Tel: 01903 737756
Email: planning@arun.gov.uk
www.arun.gov.uk/planning
Please ask for: Ms Iqraa Malik
Email: iqraa.malik@terraquest.co.uk
Telephone: 0121 234 1390
Our Ref: FP/137/25/HH
Your Ref:
Date: 22nd September 2025

Application for Planning Permission for Works or Extension to a Dwelling

Development: Single storey side extension.
Location: 13 Berewecke Road Felpham PO22 7EG

PROPOSED ELEVATIONS

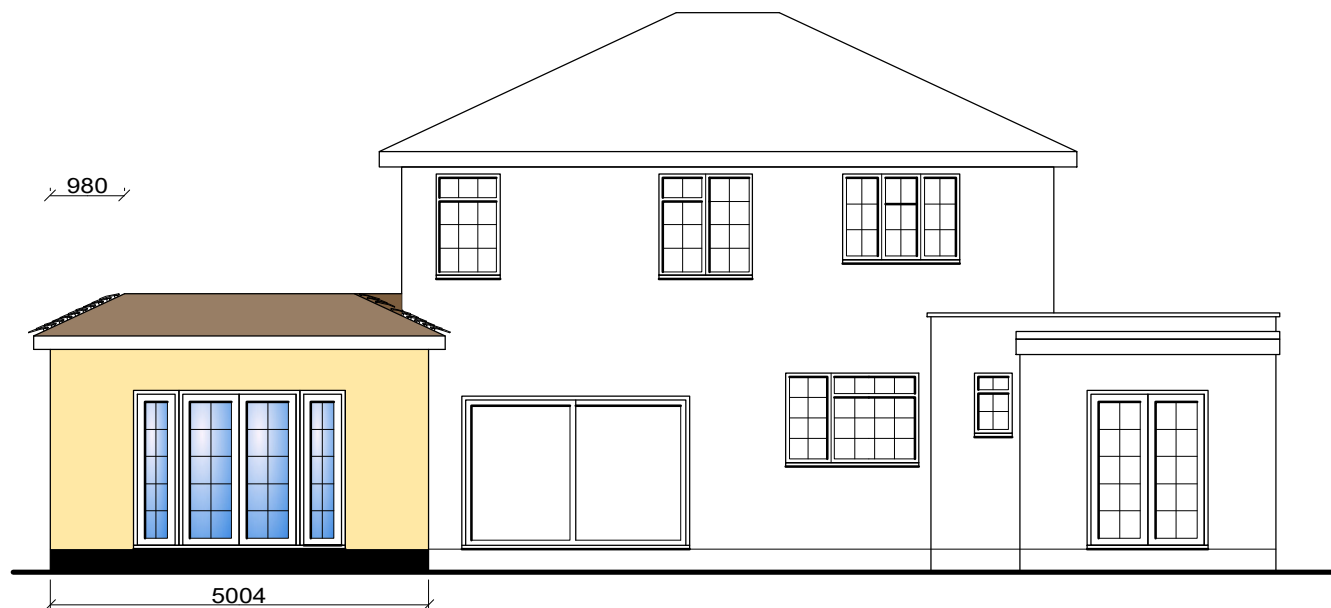
Inconsistent Plans

The side elevations are inconsistent with the ground floor plans, please review and amend.
